# SUNNICA ENERGY FARM

8.112 The Applicant's position on 'parcel by parcel' mitigation and residual effects

<b>Planning Inspectorate Scheme Reference</b>	EN010106
<b>Application Document Reference</b>	EN010106/APP/8.112
<b>Author</b>	Sunnica Energy Farm Project Team

<b>Version</b>	<b>Date</b>	<b>Status of Version</b>
Rev 00	13 March 2023	Deadline 8 Submission

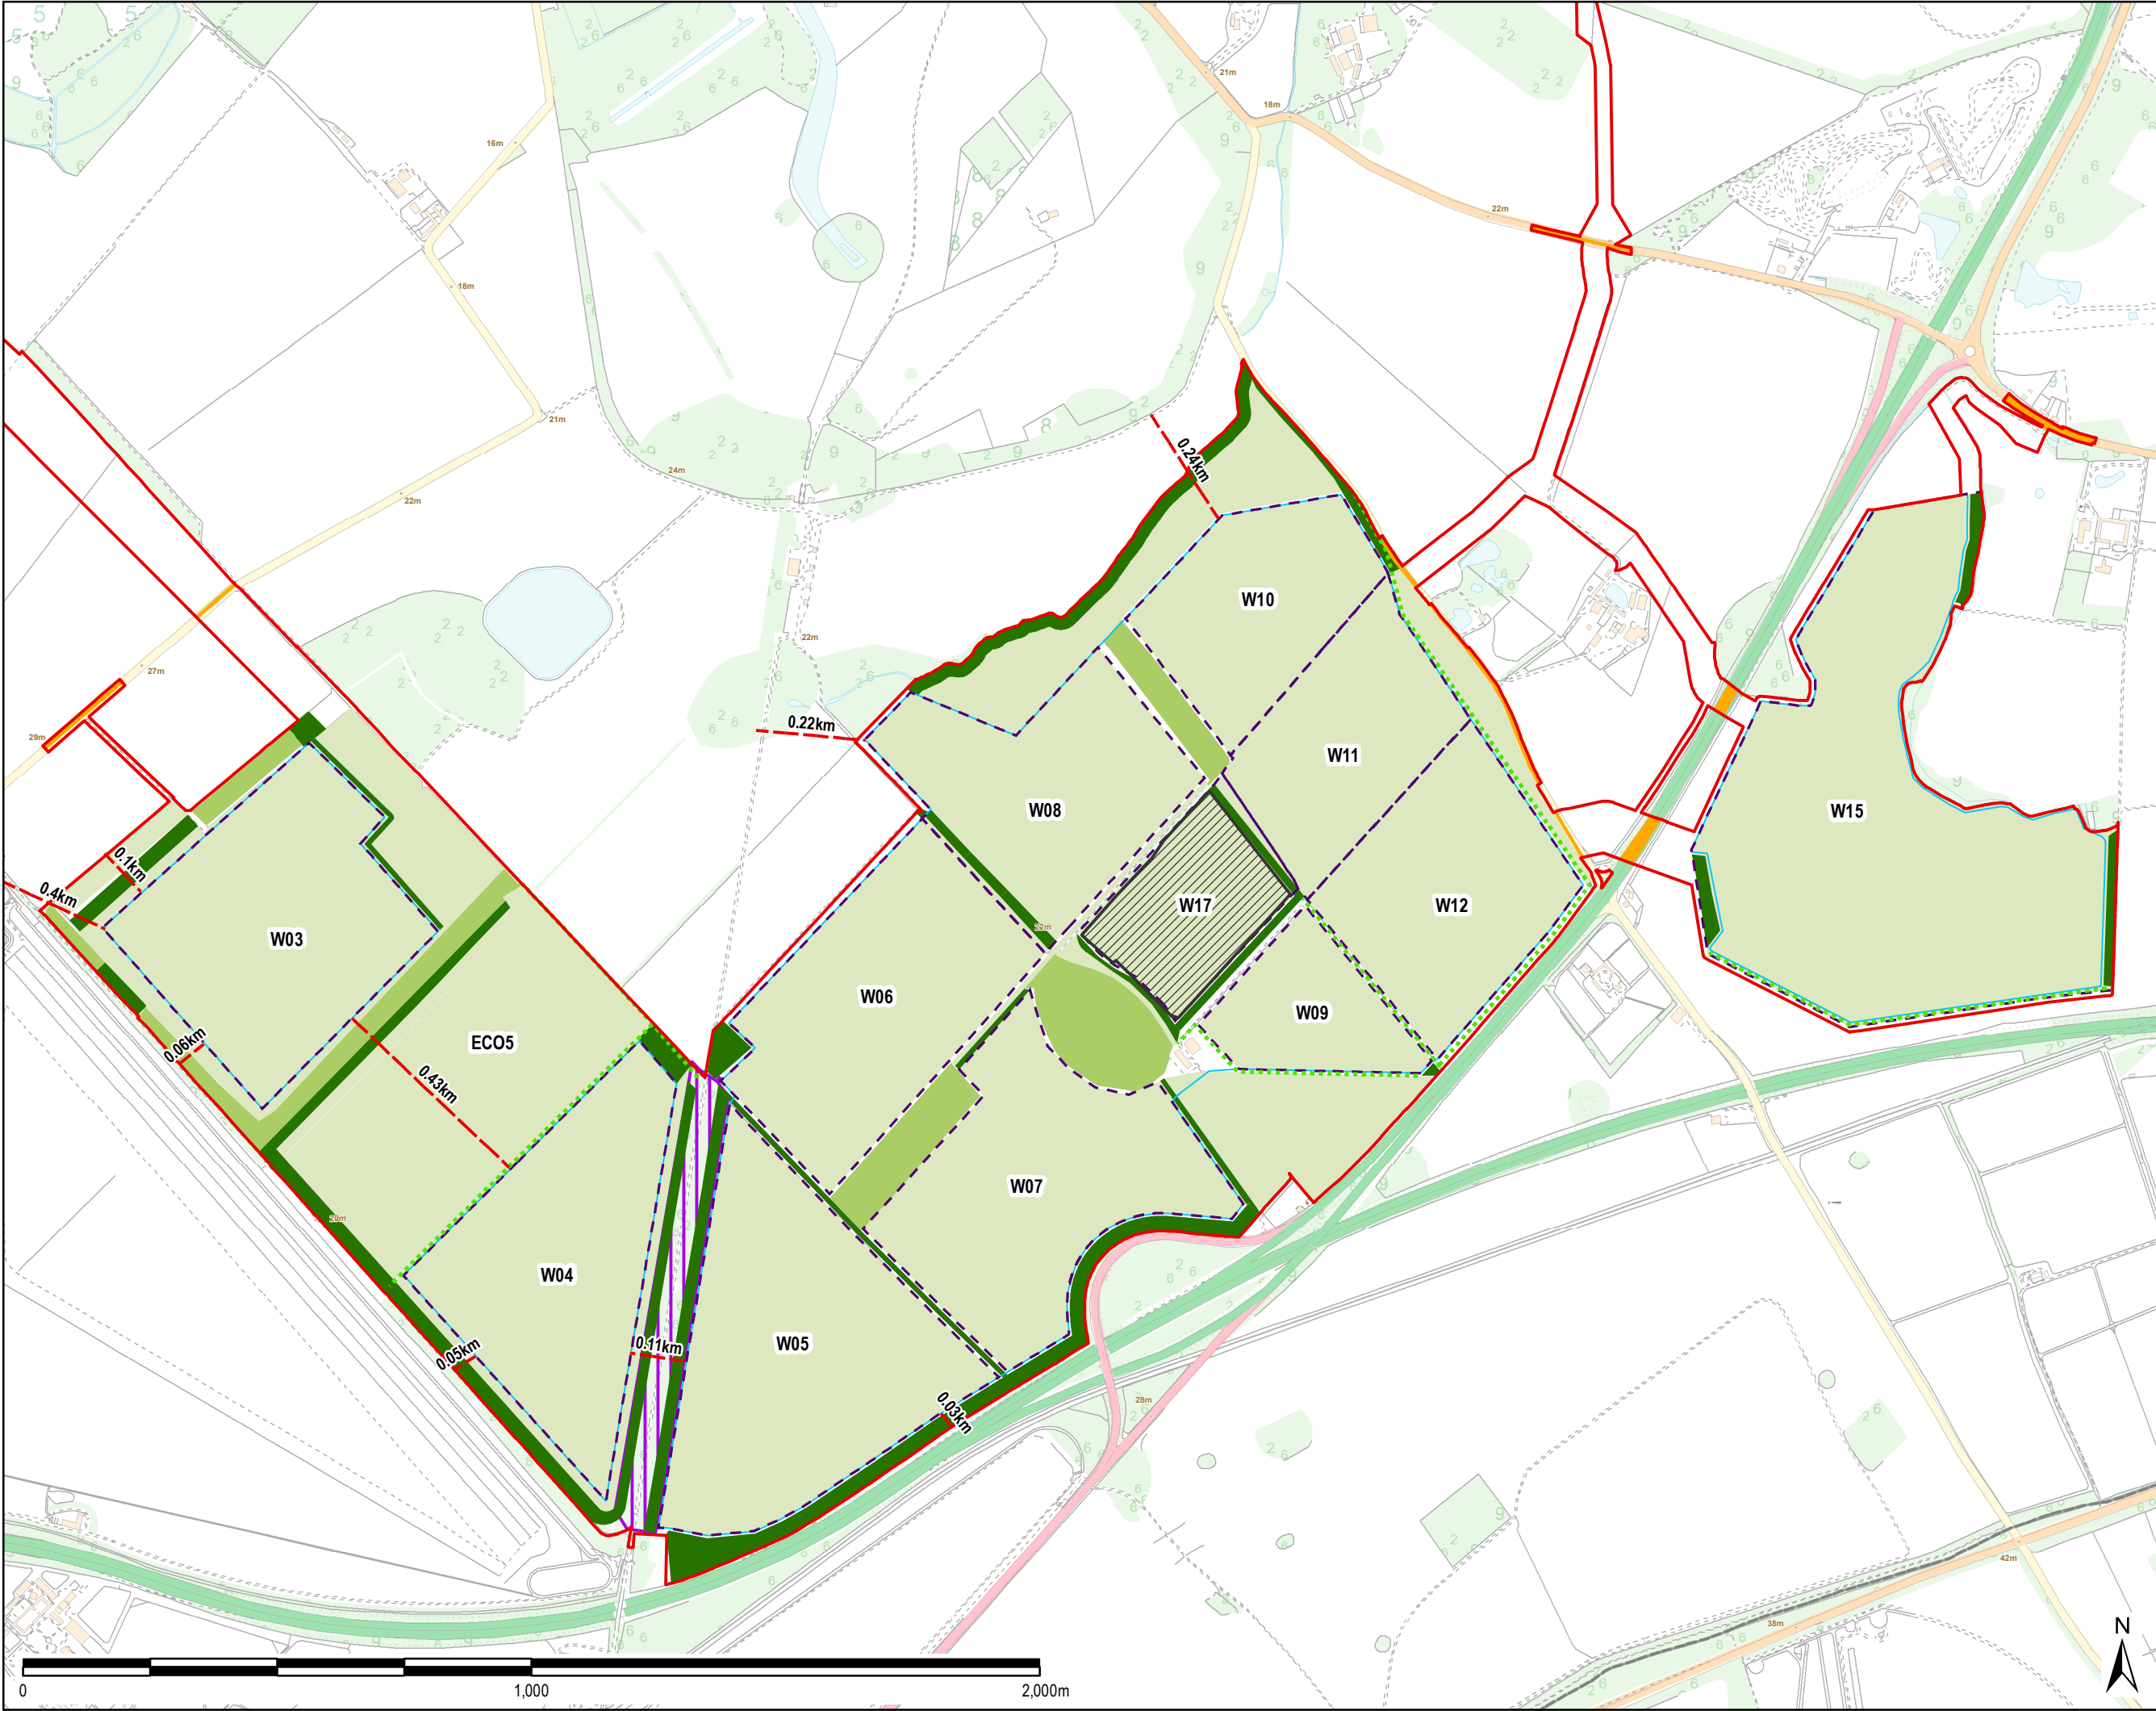
<b>W02</b>	No longer proposed.	Effects from the construction of the cable route. Not fully assessed on their own.	Proposals for post-construction landscape and ecology restoration required.	This has not yet been discussed with the applicant and no proposals have been submitted.	Currently unclear.  If no vegetation is lost and land restored after construction, landscape and visual effects are expected to be short term only.	Omitted from the Scheme. The replacement of vegetation removed to facilitate construction of the cable route will be addressed in accordance with the OLEMP [REP7-015].
<b>ECO4</b>	No longer proposed.	Effects from the construction of the cable route. Not fully assessed on their own.	Proposals for post-construction landscape and ecology restoration required.	This has not yet been discussed with the applicant and no proposals have been submitted.	Currently unclear.  If no vegetation is lost and land restored after construction, landscape and visual effects are expected to be short term only.	Omitted from the Scheme. The replacement of vegetation removed to facilitate construction of the cable route will be addressed in accordance with the OLEMP [REP7-015].

<b>W04</b>	New native chalk grassland across part	The placement of solar panels within the	Without prejudice, as for W10 the extent of	This has not been discussed in detail with	Even with the set-back the residual changes to	The hedgerow along the north western

<b>W05</b>	<p>Siting the solar panels away from The Avenue so that new woodland can be implemented along the southern edges of the parcel, which is considered appropriate in the context of the Avenue and Chippenham Park.</p>	<p>The proposals for this parcel are unclear.</p> <p>The placement of solar panels within the setting of, and in close proximity to, the Registered Park and Garden, eliminates the currently existing time-</p>	<p>Without prejudice, as for W10 the extent of the solar panels should be located to ensure a physical separation from the boundary wall of Chippenham Park and Chippenham Hall. Therefore, the off-set of the solar panels from the outer edge of The</p>	<p>This has not been discussed in detail with the applicant as the Councils' primary position remains that this development is unsuitable for the historic landscape, and the resulting effects are not capable of being</p>	<p>Even with the set-back the residual changes to the character of the historic landscape and views to and from The Avenue are substantial and result in detrimental effects, including the elimination of the experience of time-</p>	<p>The existing hedgerow along the north eastern boundary of W05 follows an existing field boundary [REP7-054] and will be reinforced with additional tree and shrub planting to enhance habitat</p>

<b>W06</b>	New woodland planting to the west of the parcel, to reduce their visibility in longer distance views from The Limekilns, as well as provide new vegetation links across the landscape.  The existing woodland between these parcels has also been retained, with panels and associated infrastructure offset from the woodland.	The proposals are unclear, as the parcel boundaries run north-west and south-west.  On the south-western boundary The Environmental Plan (sheet 13) shows 'planting to reinforce the existing hedgerow between parcels W05 and W07', which appears to continue between W05 and W06. This is welcome.	Without prejudice, as for W10 the extent of the solar panels should be located to ensure a physical separation from the boundary wall of Chippenham Park and Chippenham Hall. Therefore, the off-set of the solar panels from the outer edge of The Avenue should be the same distance as W10 is set back from Chippenham Park.  The hedge along the north-western	This has not been discussed in detail with the applicant as the Councils' primary position remains that this development is unsuitable for the historic landscape, and the resulting effects are not capable of being sufficiently mitigated to be made acceptable.	A long-term increase in residual effects on existing (and proposed) trees can be avoided, if the siting of panels takes account of accurate shading predictions.  Even with the set-back the residual changes to the character of the historic landscape and views to and from The Avenue are substantial and result in detrimental effects, including the	The future shading of panels is taken account of in the layout and design of the Scheme allowing for future growth as set in the OLEMP [REP7-015]. The proposed planting follows existing field boundaries to enhance habitat connectivity and enclosure [REP7-054].

<b>W15</b>	The solar panels have been offset from the watercourse, along with the retention of the riverside trees and	With the current proposals <b>W15</b> would be likely to be <b>remain visible form the A11</b>	Mitigation around perimeter needs to be more robust.	This has been discussed with the applicant, but insufficient progress was made.	Residual visual effects of the parcel would be reduced to close to zero over the medium to long-term.	The OLEMP <b>REP7-015</b> ] has been reviewed to reflect the proposals now shown on the Environmental

<b>W17</b>	<p>Siting the primary construction compound and the BESS and substation within W17, so that it is in part adjacent to existing barns and bordered by the mature woodland of Sounds Plantation which aids in screening the structures from the west and in views from the east, their suitable rendering in the context of the woodland, to aid in reducing the perceived</p>	<p>The photomontage of VP33 [APP-229] suggests that some of the built structures would be breaking the skyline and would be visible, even at year 15, <b>adversely affecting views from La Hogue Road</b>, including the Farm Shop entrance.</p> <p><b>Tree loss:</b> While not shown on the Environmental Plan, the AIA [REP5-</p>	<p>Without prejudice, the built structures should be designed and sited, as far as possible, so that do not break the skyline.</p> <p>Justification should be provided why these trees need to be removed. Any Category A/B trees or Veteran trees that may be surveyed at a later stage should be retained.</p>	<p>This has been discussed with the Applicant. However, no further information is expected to come forward prior to the detailed design stage post determination.</p> <p>The Councils have raised concerns with regards to insufficient arboricultural and hedgerow information on multiple occasions.</p>	<p>The residual effects would be minimised.</p> <p>However, detrimental residual effects on the historic landscape and the setting of the Chippenham Registered Park and Garden remain.</p>	<p>Further detail has been added to the OLEMP [REP7-015] and Environmental Masterplan [REP7-054] to explain how existing vegetation will be strengthened through planting to reinforce visual screening and enclosure.</p>

Ref.	Current proposals as detailed in OLEMP [REP5-014]	Residual effects	Further mitigation required [REP4-149] and LIR [REP1-024]	Applicants mitigation under discussion/or not yet shown on EnvM –[AS-324] and/or [AS-321]	Residual effects if the Council's mitigation is implemented in full	Applicant's response at Deadline 8
<b>W03</b>	Siting the solar panels between woodland blocks and Foxburrow Plantation and reinforcing the vegetation patterns with new woodland planting to aid in screening this part of the Scheme from the wider landscape and retaining a physical separation from Chippenham Road and Snailwell.	<p>The proposed woodland block on the north-western edge of W03 would <b>block the long-distance views</b> across the undulating landscape to the south-east from Bridleway 204/5 (VP41).</p> <p><b>Loss of TPO trees:</b> Although it has now been proposed to retain the TPO trees at the existing Field entrance north-west of W03, the crown lifting will have a negative impact on the avenue's appearance. There is further a risk that the trees either side of the access will be damaged through vehicle overrun and soil compaction. It is expected that three trees would need to be removed at the north-eastern end of the avenue to enable the cable route (AIA)</p>	<p>Without prejudice, the DCO limits need to be moved further south-east, so that panels and mitigative planting would be situated in such a way that the views would be retained long-term. (See VP41).</p> <p>The use of the existing field track should be omitted from the scheme and an access created within the cable corridor to minimise the adverse effects on the avenue on Chippenham Road. Unless the cable is installed by directional drilling that would then avoid the loss of the 2 or 3 TPO trees which would be a preferable solution.</p>	<p>This has not yet been discussed with the applicant.</p> <p>This has been discussed with the applicant, but insufficient progress was made. The suggestion of using horizontal drilling has been made to the applicant but no response has been forthcoming or confirmation as to how many TPO trees will be lost.</p>	<p>The residual visual impacts on the Prow 204/5 (VP41) would be significantly reduced, beginning from construction, as the works in W03 would be screened by landform.</p> <p>The young avenue on Chippenham Road would remain visually coherent and largely intact.</p> <p>In the medium to long-term it is expected that there would be no residual visual effects from this location, as the long- distance view would be retained and the solar panels would be screened by a hedge.</p> <p>However, detrimental effects on the historic landscape and the setting of the Chippenham</p>	<p>The applicant has confirmed that the existing Chippenham Road access is required for construction and operation. The applicant maintains that crown lifting a single tree (T332) will not result in a significant impact on the tree or have a negative impact on the Chippenham Road avenue as a whole. The tree has already been subject to crown lifting for the existing highway clearance and there is a degree of variation in crown heights and forms across Chippenham Road avenue trees.</p> <p>The new access to the north east north is required for construction only. The use of trenchless installation would not</p>

Ref.	Current proposals as detailed in OLEMP [REP5-014]	Residual effects	Further mitigation required [REP4-149] and LIR [REP1-024]	Applicants mitigation under discussion/or not yet shown on EnvM –[AS-324] and/or [AS-321]	Residual effects if the Council's mitigation is implemented in full	Applicant's response at Deadline 8
	<p>of the parcel, in response to below ground archaeology.</p> <p>The solar panels have also been sited away from The Avenue so that new woodland can be implemented.</p> <p>A temporary fence, rendered in a colour to aid its integration in the landscape will also be implemented in relation to views from Godolphin Gallops, until the establishment of the proposed planting, secured via the OLEMP.</p>	<p>setting of, and in close proximity to, the Registered Park and Garden, eliminates the currently existing time-depth of this area and detrimentally undermines the legibility of The Avenue in the landscape.</p> <p>Although The Avenue to Chippenham Estate is in many parts densely vegetated, there are gaps that allow views out of the corridor, especially to the west towards parcel W04.</p>	<p>the solar panels should be located to ensure a physical separation from the boundary wall of Chippenham Park and Chippenham Hall. Therefore, the off-set of the solar panels from the outer edge of The Avenue should be the same distance as W10 is set back from Chippenham Park</p> <p>The gaps in Avenue should be closed with appropriate planting suitable to the landscape character.</p>	<p>the applicant as the Councils' primary position remains that this development is unsuitable for the historic landscape, and the resulting effects are not capable of being sufficiently mitigated to be made acceptable.</p>	<p>the character of the historic landscape and views to and from The Avenue result in substantial detrimental effects, on the setting of the RPG. This is compounded by the fact that mitigation planting in form of hedging would be inappropriate in this landscape, as the hedge would run diagonal to the existing and historic field pattern.</p>	<p>boundary of W04 follows an existing field boundary [REP7-054]. Additional planting within the Avenue is shown on the Environmental Masterplans [REP7-054] to reinforce the original alignment. The detail of this planting will be agreed post-consent.</p> <p>The avenue was historically intended to provide views through. This would be prevented if the gaps were closed and would cause additional impacts to the RPG.</p>

Ref.	Current proposals as detailed in OLEMP [REP5-014]	Residual effects	Further mitigation required [REP4-149] and LIR [REP1-024]	Applicants mitigation under discussion/or not yet shown on EnvM –[AS-324] and/or [AS-321]	Residual effects if the Council's mitigation is implemented in full	Applicant's response at Deadline 8
	There would also be a new woodland mix along the southern edge of the parcel which would include a higher percentage of evergreen species and a temporary fence, rendered in a suitable colour, to screen views from motorists on the A14, secured via the OLEMP.	depth of this area and detrimentally undermines the legibility of The Avenue in the landscape.  The inclusion of a clump of conifers changes the species composition and the character of The Avenue (RPG).	Avenue should be the same distance as W10 is set back from Chippenham -Any gaps in Avenue should be closed with appropriate planting suitable to the landscape character.	sufficiently mitigated to be made acceptable.	depth within the setting of the RPG. This is compounded by the fact that mitigation planting in form of hedging would be inappropriate in this landscape, as the hedge would run diagonal to the existing and historic field pattern.	connectivity and enclosure. Additional planting within the Avenue is shown on the Environmental Masterplans [REP7-054] to reinforce the original alignment. The detail of this planting will be agreed post-consent.

Ref.	Current proposals as detailed in OLEMP [REP5-014]	Residual effects	Further mitigation required [REP4-149] and LIR [REP1-024]	Applicants mitigation under discussion/or not yet shown on EnvM –[AS-324] and/or [AS-321]	Residual effects if the Council's mitigation is implemented in full	Applicant's response at Deadline 8
			<p>boundary of W06 (H15) is the only one that has been identified by the applicant to be an important hedgerow under the Hedgerow Regulations 1997 [APP-079, Appendix 8C - Terrestrial Habitats and Flora Report, 5.3.1. and Fig 3.2]. It contains several mature beech trees.</p> <p>Where W06 extends to the hedge, the off- set from this hedge should be no less than 10m from the outer rim of the canopy of the mature hedgerow trees to preserve the RPAs and improve the likelihood of its successful establishment.</p> <p>However, potential shading of solar panels by the existing and proposed trees should be allowed for, which</p>		elimination of the experience of time-depth within the setting of the RPG. This is compounded by the fact that mitigation planting in form of hedging would be inappropriate in this landscape, as the hedge would run diagonal to the existing and historic field pattern.

Ref.	Current proposals as detailed in OLEMP [REP5-014]	Residual effects	Further mitigation required [REP4-149] and LIR [REP1-024]	Applicants mitigation under discussion/or not yet shown on EnvM –[AS-324] and/or [AS-321]	Residual effects if the Council's mitigation is implemented in full	Applicant's response at Deadline 8
	<p>vegetation and road networks.</p> <p>New woodland is proposed around the perimeter of the parcels to screen the Scheme, as well as to soften views of the A11 from Kennett and increase the vegetation.</p>	<p>through gaps in the roadside vegetation.</p> <p>There may be <b>views onto the solar farm from Dane Hill Cottages</b> (which was not assessed in detail).</p>	<p>The offset from the watercourse needs to be clarified,</p> <p>Riparian vegetation should be strengthened.</p> <p>Along the boundaries where no woodland or hedge is currently proposed further planting proposals are required.</p>			Masterplan for W15 <b>REP7-054</b> ].

Ref.	Current proposals as detailed in OLEMP [REP5-014]	Residual effects	Further mitigation required [REP4-149] and LIR [REP1-024]	Applicants mitigation under discussion/or not yet shown on EnvM –[AS-324] and/or [AS-321]	Residual effects if the Council's mitigation is implemented in full	Applicant's response at Deadline 8
	overall massing of the structures;	052/053] show several trees (including some that look very mature) as earmarked to be removed from the existing hedgerow between W17 and W08. These trees have not yet been accurately assessed.
